TO: Allison Kimball, CDS  
FROM: Christina Wollman, Planner II *cw*  
DATE: December 1, 2008  
SUBJECT: White Water Performance Based Cluster Plat LP-08-28  
Additional Information Required

The following additional information shall be required prior to the issuance of Conditional Preliminary Approval:

**WHITE WATER**  
**PERFORMANCE BASED CLUSTER PLAT**  
 PTN. NORTH 1/2, SECTION 1, T.19N., R.15E., W.M.  
 KITTITAS COUNTY, STATE OF WASHINGTON

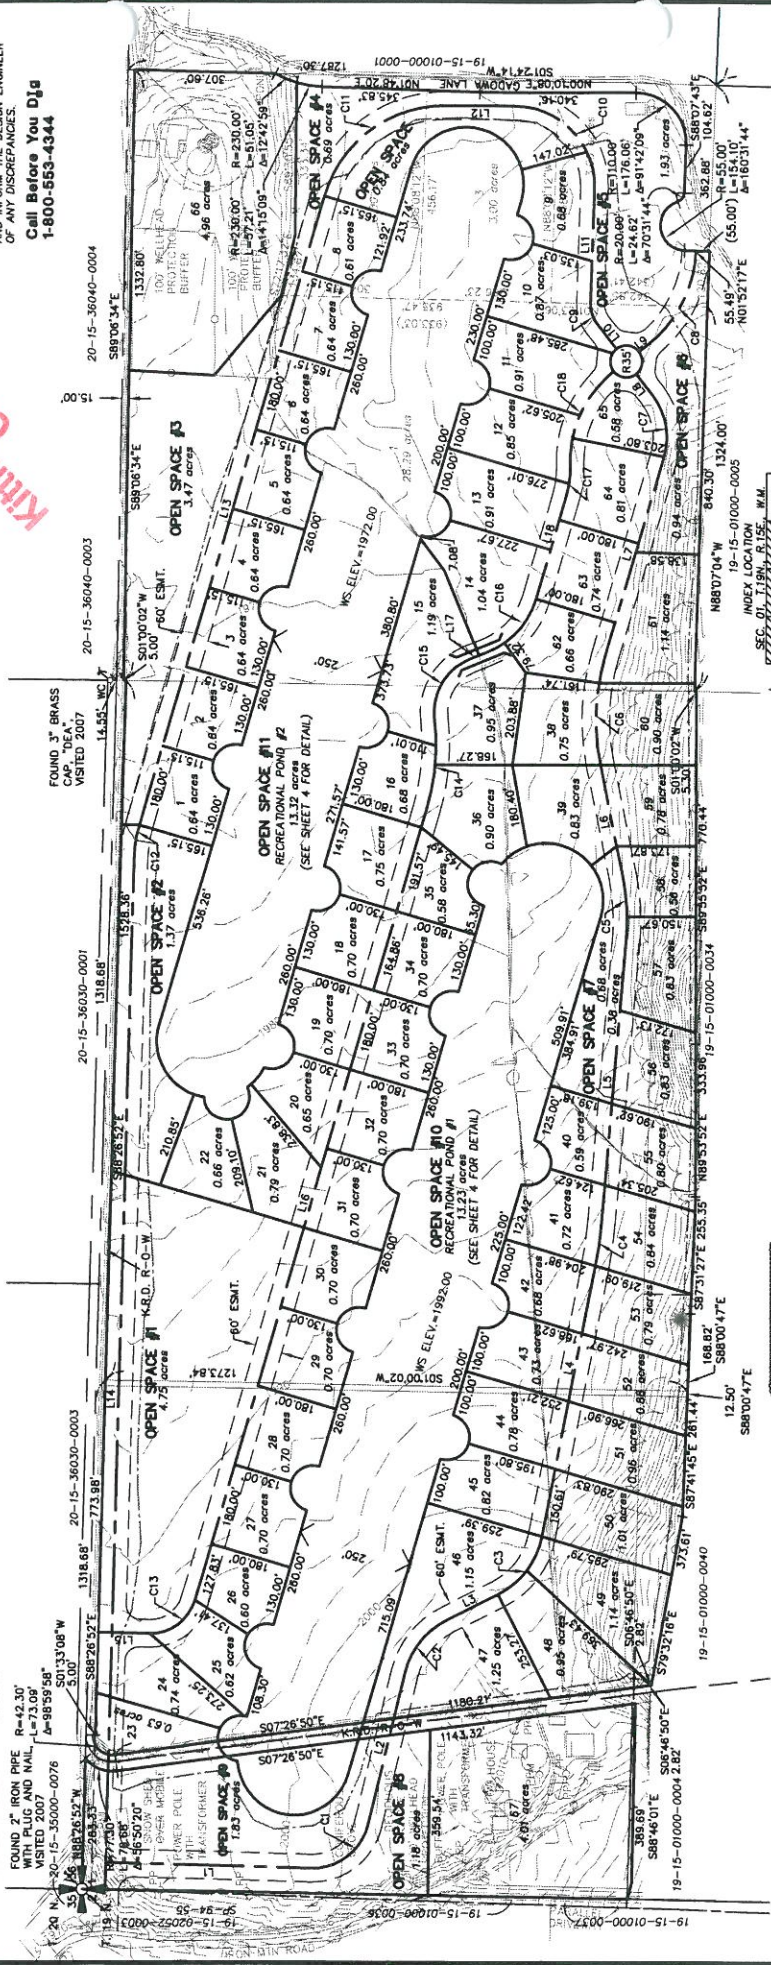
1. Intersection: Additional information regarding the intersection at Pays Road shall be provided. The information shall detail the easement leading from the subject property to Pays Road and show where the approach will be in relation to Iron Mountain Road. An engineered drawing of the intersection at Pays Road shall be provided.

3. County Road Right-of-Way: A connection between Pays Road and Godawa Lane is identified in the Kittitas County Transportation Plan. The applicant may be required to dedicate right-of-way. Exact location will need to be determined with Public Works.
